From: Sarah Burrow <Sarah.Burrow@arun.gov.uk>
Sent: 21 October 2019 12:11
To: Planning.Responses <Planning.Responses@arun.gov.uk>
Cc: Maria Tomalova <Maria.Tomalova@arun.gov.uk>
Subject: BR/63/19/PL

Engineers Comments Regarding Surface Water Drainage

Project:-			
Proposed Residential Development 15-17 Kew Gardens Bognor Regis West Sussex			
Title:-			
Proposed Site Plan			
Client:-			
Farnden Developments Ltd			
Scale:-			
1:100 (@A1)			
Drawn By:-		Checked By:-	
PJD			
Date:-		Date:-	
14/02/19			
Job.No:-		Drg.No:-	
180037		03

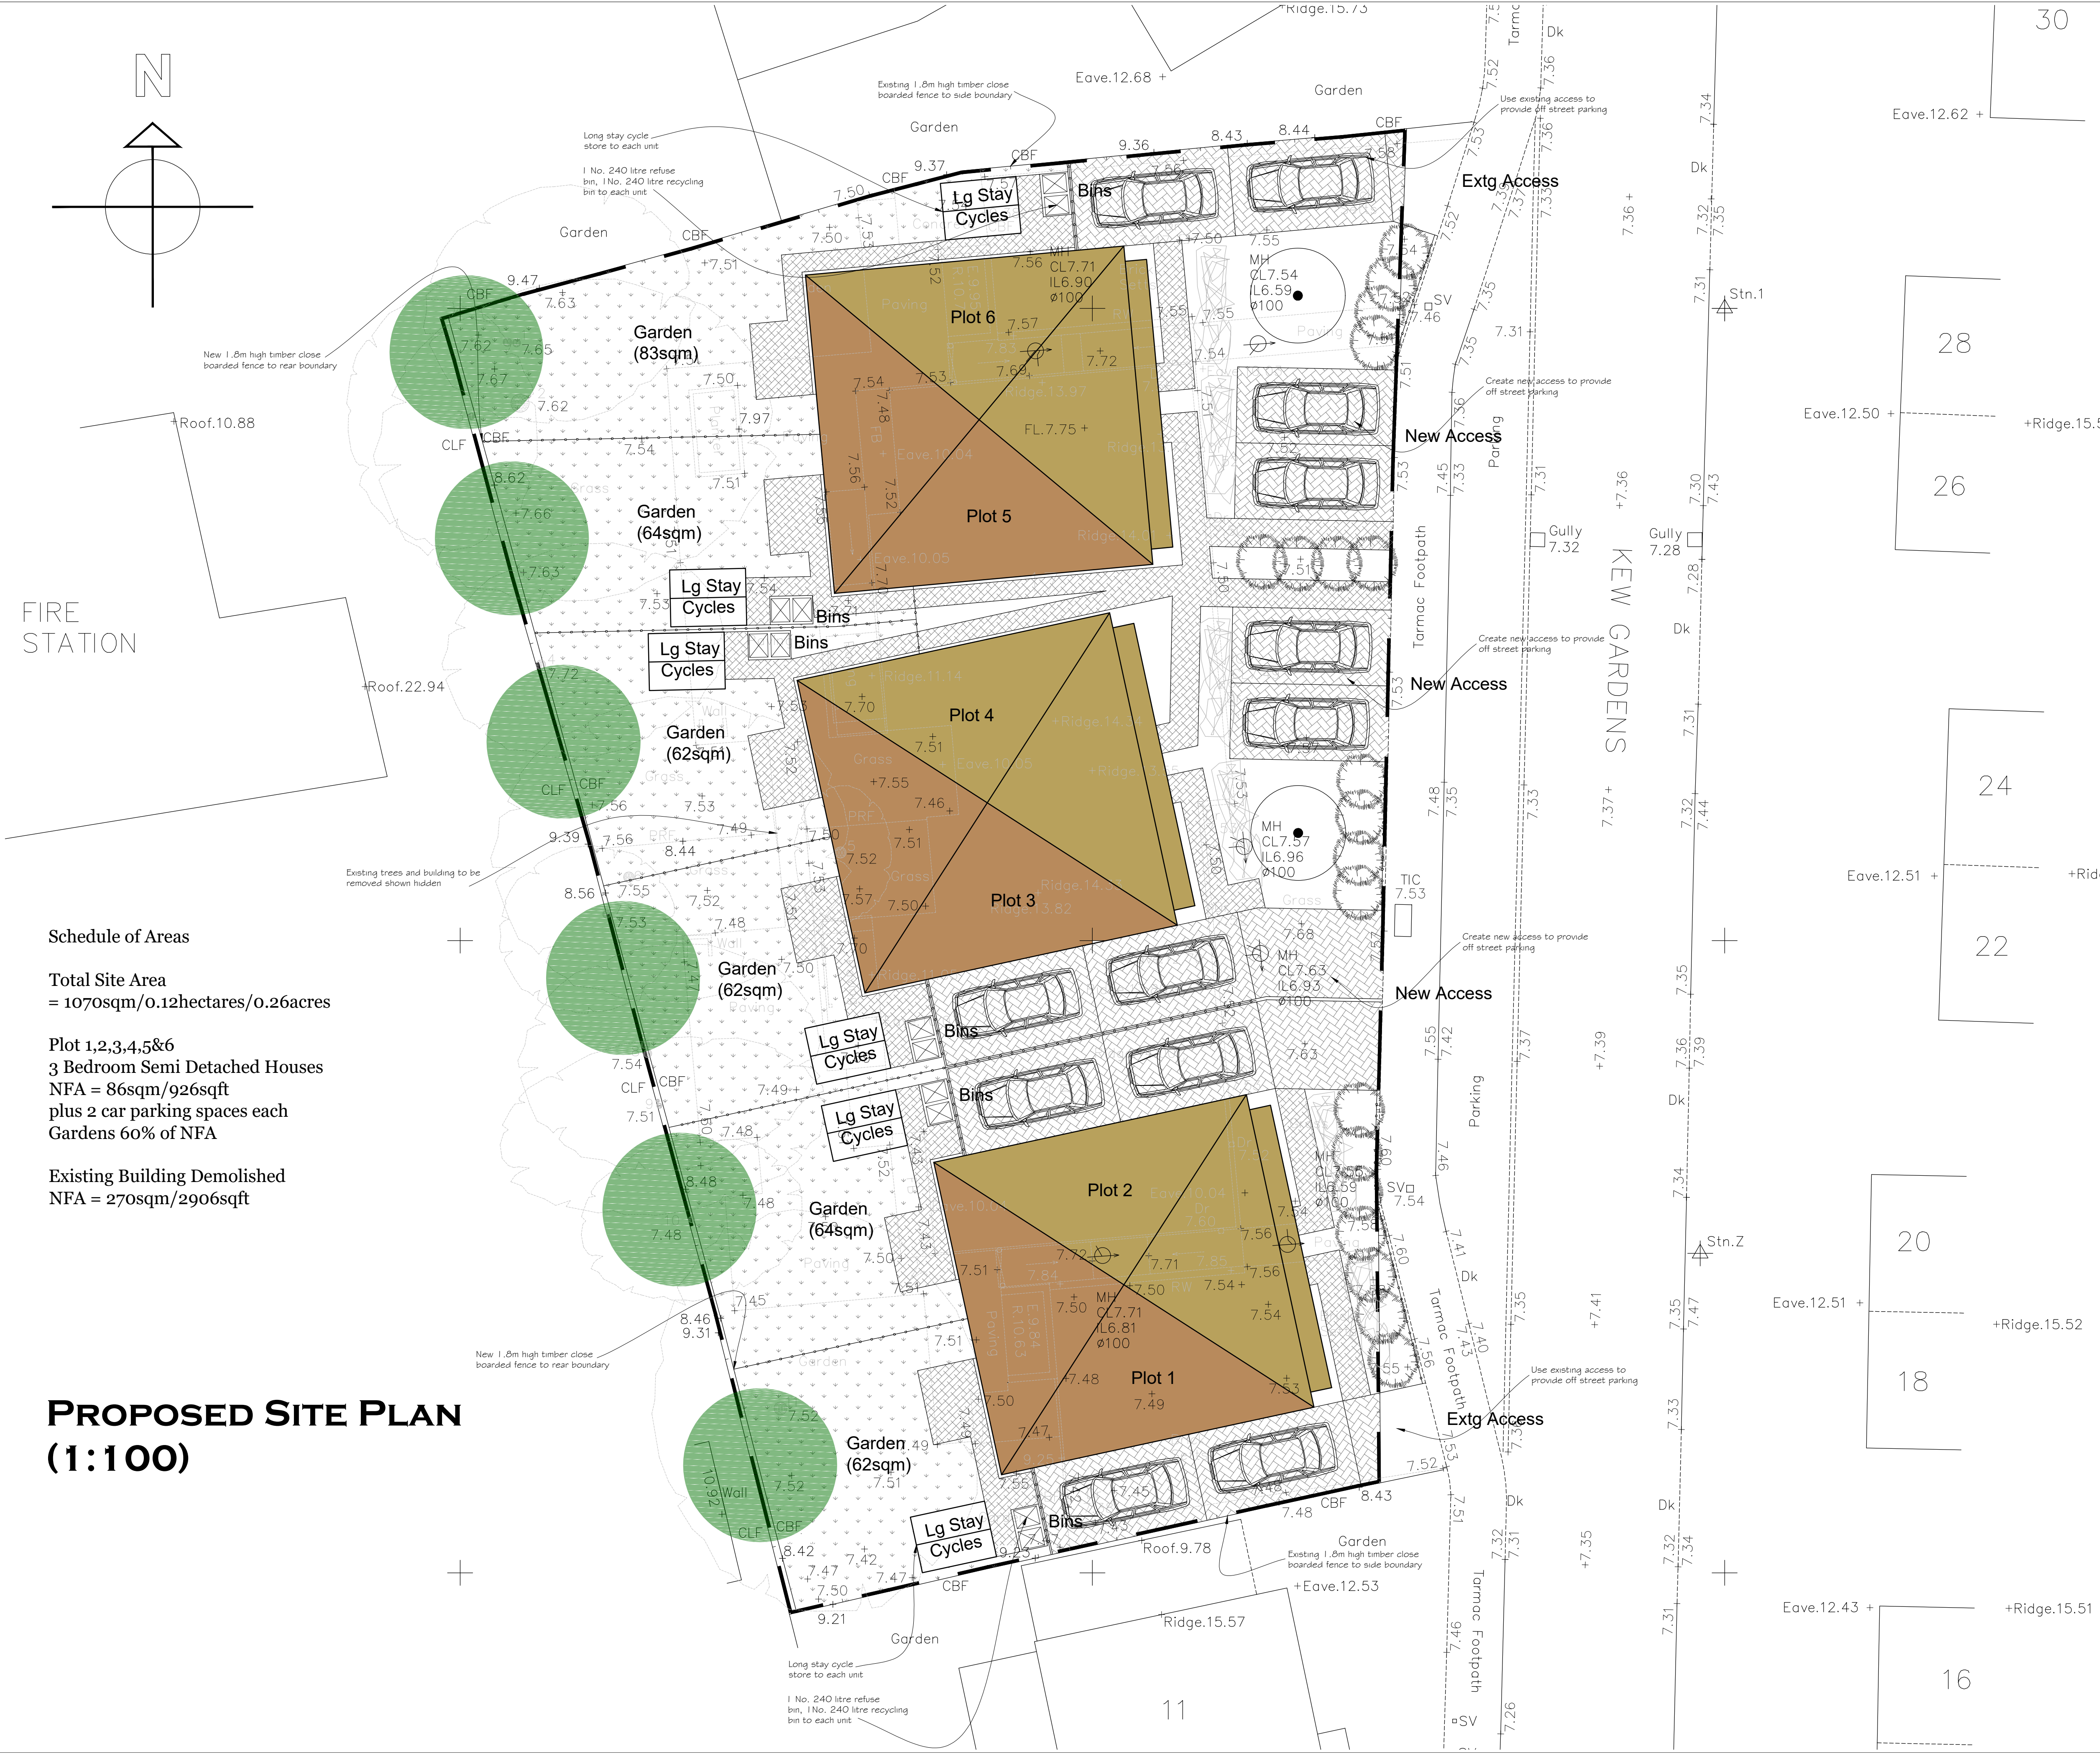
There have been concerns raised that there is not enough space for surface water drainage within the proposed site layout. The proposed surface water drainage design is on the basis of estimated figures, as such there is a possibility that the ground conditions evidenced upon testing will require the strategy to be revised.

"Development shall not commence, other than works of site survey and investigation, until full details of the proposed surface water drainage scheme have been submitted to and approved in writing by the Local Planning Authority. The design should follow the hierarchy of preference for different types of surface water drainage disposal systems as set out in Approved Document H of the Building Regulations, and the recommendations of the SuDS Manual produced by CIRIA. Winter groundwater monitoring to establish highest annual ground water levels and winter Percolation testing to BRE 365, or similar approved, will be required to support the design of any Infiltration drainage. No building / No part of the extended building shall be occupied until the complete surface water drainage system serving the property has been implemented in accordance with the agreed details and the details so agreed shall be maintained in good working order in perpetuity."

"Infiltration rates for soakage structures are to be based on percolation tests undertaken in the winter period and at the location and depth of the proposed structures. The percolation tests must be carried out in accordance with BRE365, CIRIA R156 or a similar approved method and cater for the 1 in 10 year storm between the invert of the entry pipe to the soakaway, and the base of the structure. It must also have provision to ensure that there is capacity in the system to contain below ground level the 1 in 100 year event plus 40% on stored volumes, as an allowance for climate change. Adequate freeboard must be provided between the base of the soakaway structure and the highest recorded annual groundwater level identified in that location. Any SuDS or soakaway design must include adequate

groundwater monitoring data to determine the highest winter groundwater table in support of the design. The applicant is advised to discuss the extent of groundwater monitoring with the Council's Engineers. Supplementary guidance notes regarding surface water drainage are located here <https://www.arun.gov.uk/surfacewater> on Arun District Councils website. A surface water drainage checklist is available here <https://www.arun.gov.uk/drainagechecklist> on Arun District Councils website, this should be submitted with a Discharge of Conditions Application."
